DEVELOPMENT REVIEW BOARD--SPEED MEMO

DRB CASE NO/PROJECT NO: 1007347

Project Name: JOURNAL CENTER

RE: Tract 4AA-6A, Journal Center

Plat of
Tract 4AA-6A-1 and 4AA-6A-2
Journal Center
 comprised of
Tract 4AA-6A, Journal Center
 City of Albuquerque
 Bernalillo County, New Mexico
 July 2008

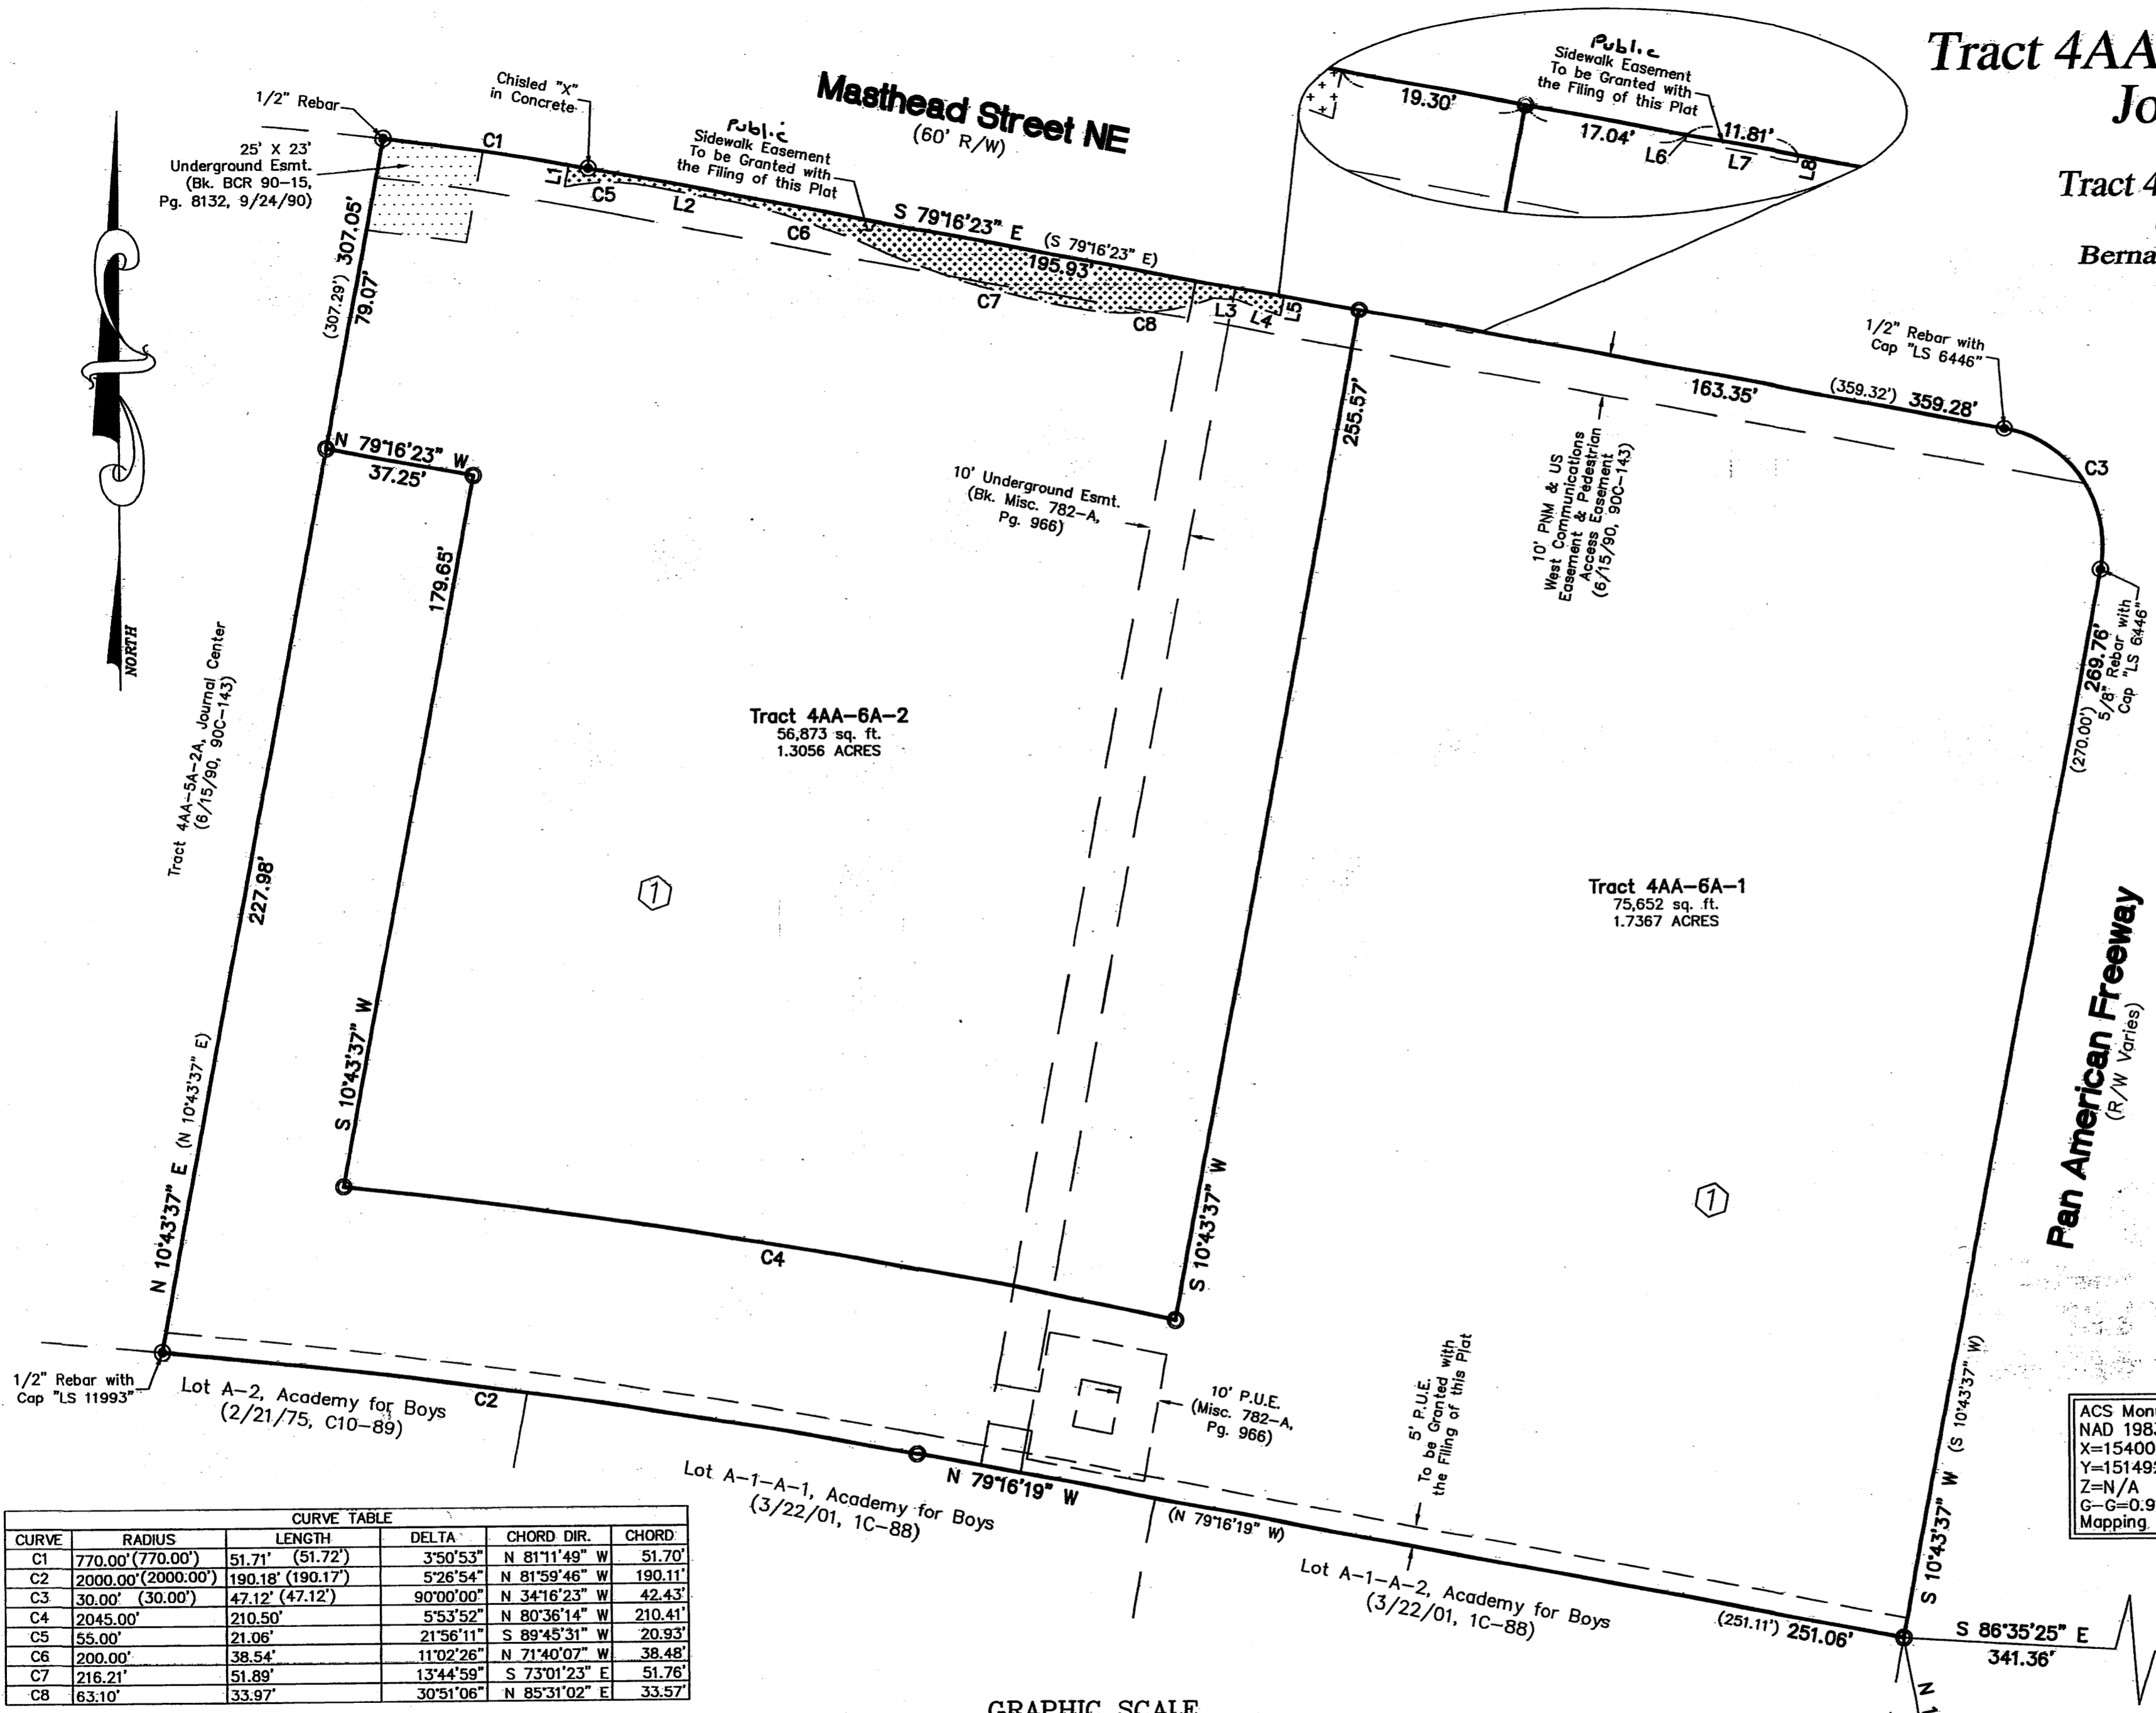
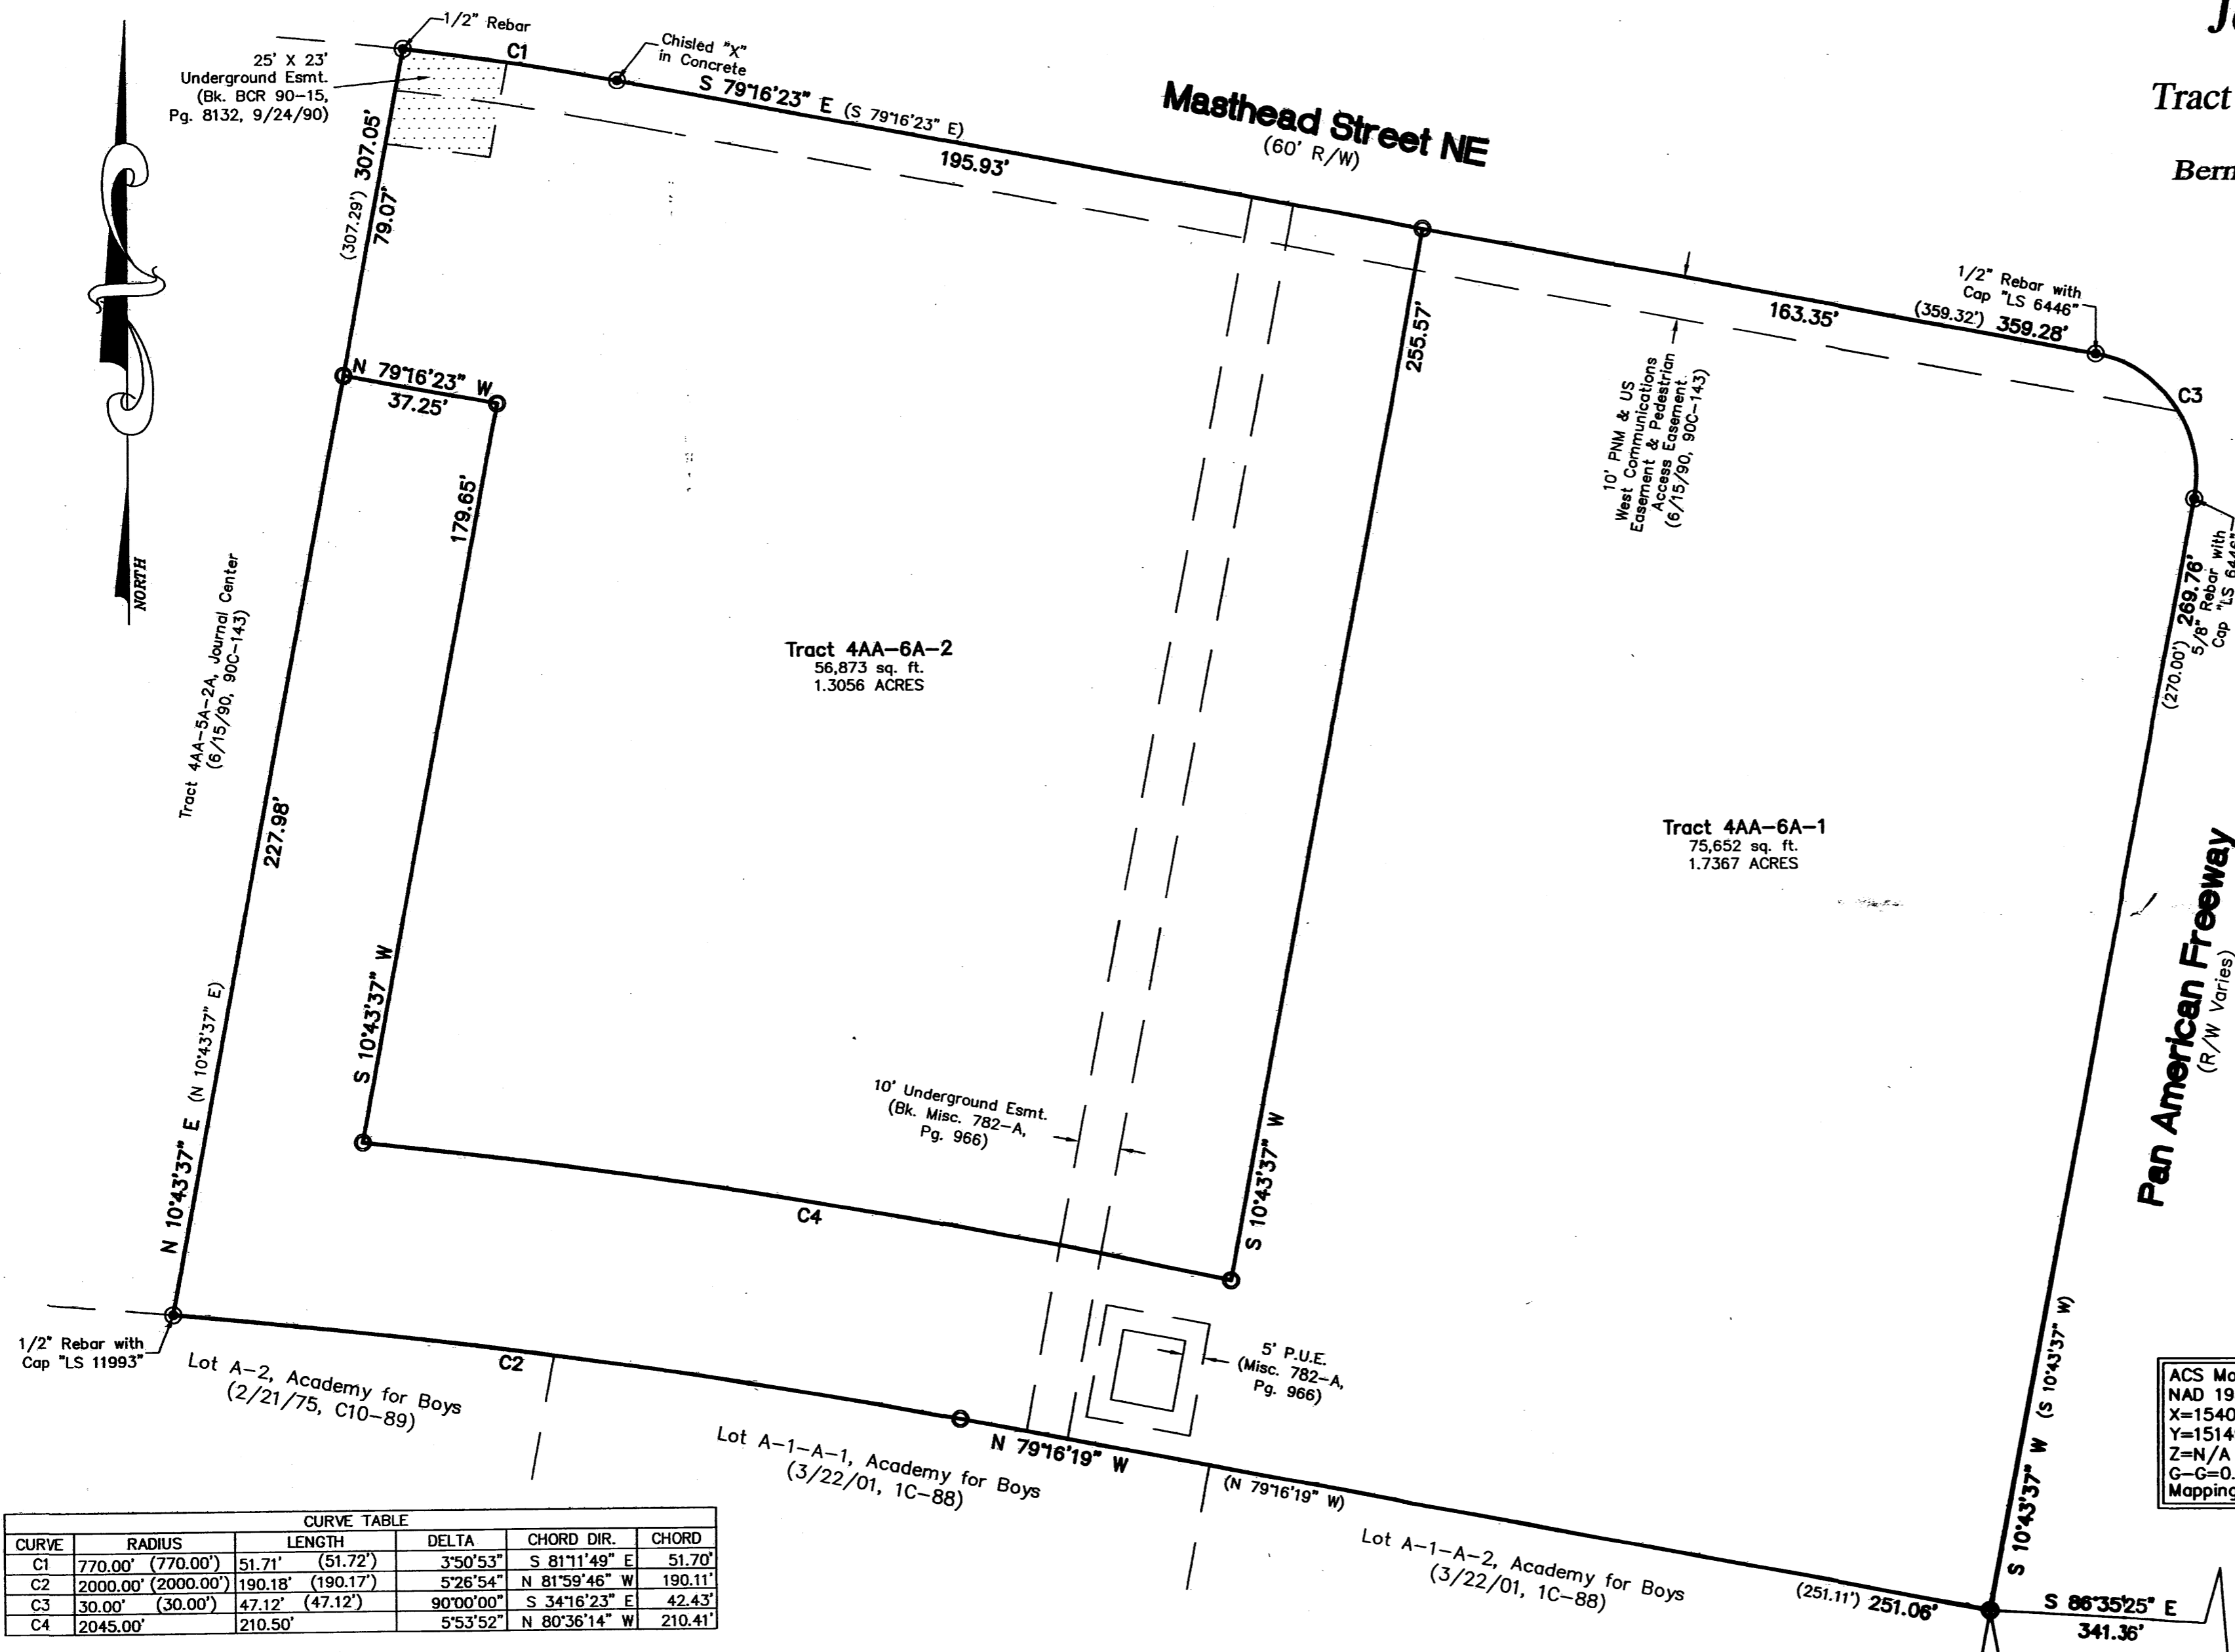
Need a ~~cross-lot drainage~~ easement.

A Solar Collector Note is needed per the Subdivision Ordinance, §14-14-4-7.

A reciprocal access, parking, and drainage easement is needed.
